FW: ACP-322985-25

Your Ref: ACP-322985-25
(Please quote in all related correspondence)

Re: Notification under the Planning and Development Act, 2000, as amended.

Proposed Development: Application for substitute consent under Section 177E of the Planning and Development Act, 2000, as amended for a camping/camp site enterprise at Clonmines, Wellingtonbridge, County Wexford.

Figure 40. Saltmarsh habitats in the Clonmines area.

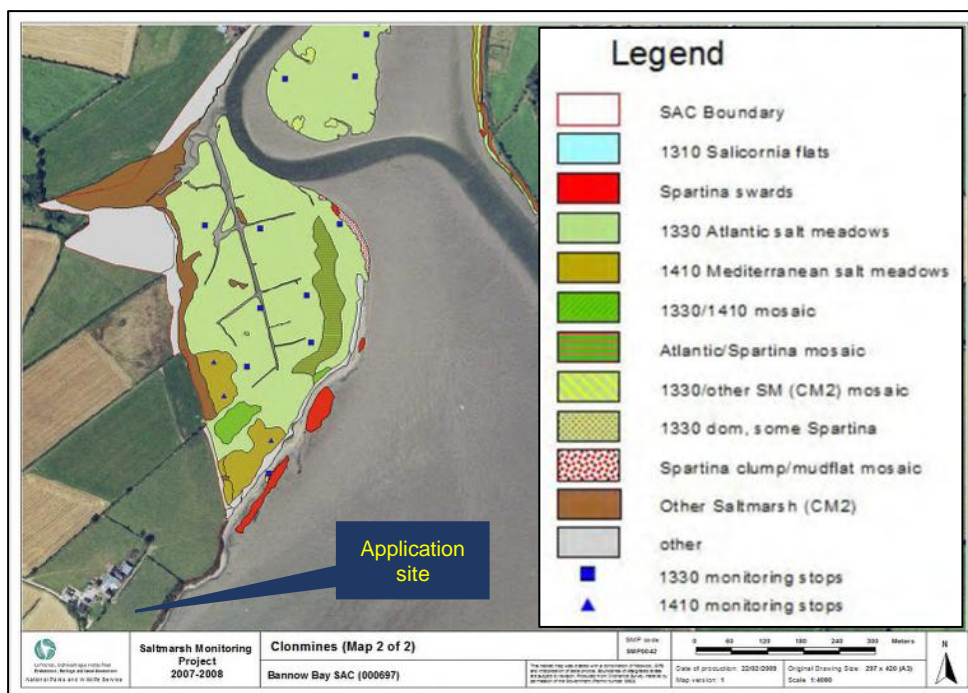
It is the Department’s view that adverse effects have already been caused by the unauthorised works and remediation works are required. SSCO for QI Mediterranean and Atlantic saltmarsh habitats, include habitat area being stable or increasing, may be contravened by these unauthorised works from increased visitors to the area due to the unauthorised development and its associated shore walk leading people to these areas. As such, there is potential for additional adverse effects to the Bannow Bay SAC and its QI saltmarsh habitats.

Figure 43. The I-WeBS Kiltra subsite (edged pale blue).

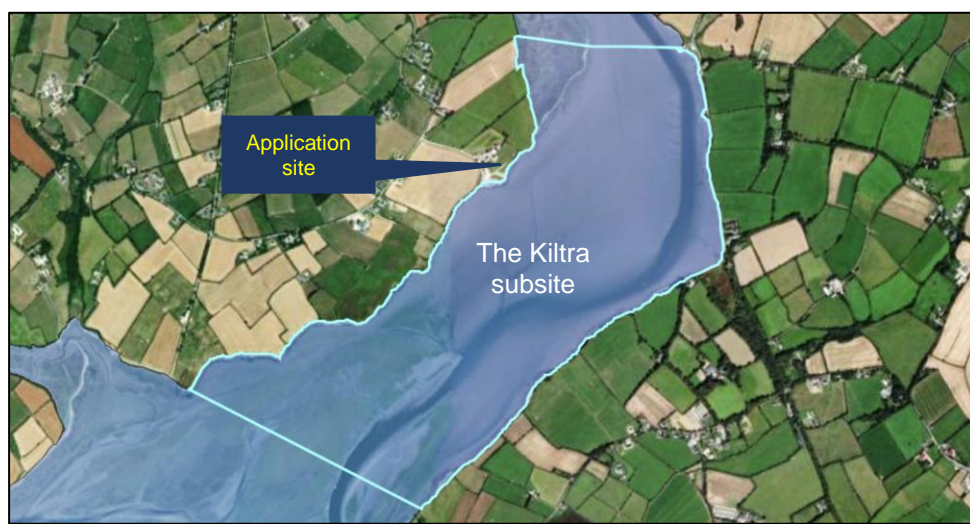
Only a single site visit was conducted on 7 January 2025 by an Ecologist. No bird surveys were carried out to inform the NIS regarding SCI bird species of Bannow Bay Special Protection Area (SPA), or the adjacent Kiltra subsite of Bannow Bay.

No data request to BWI or this Department was mentioned to inform the NIS. As such, there is a lack of recent data on the SCI bird usage of Bannow Bay SPA and Kiltra subsite.

The NIS does refer to recent reports and highlights how very important numbers of SCI bird species use Kiltra, the area of the Bay adjacent to the site, making it one of the most important subsites in Bannow Bay.
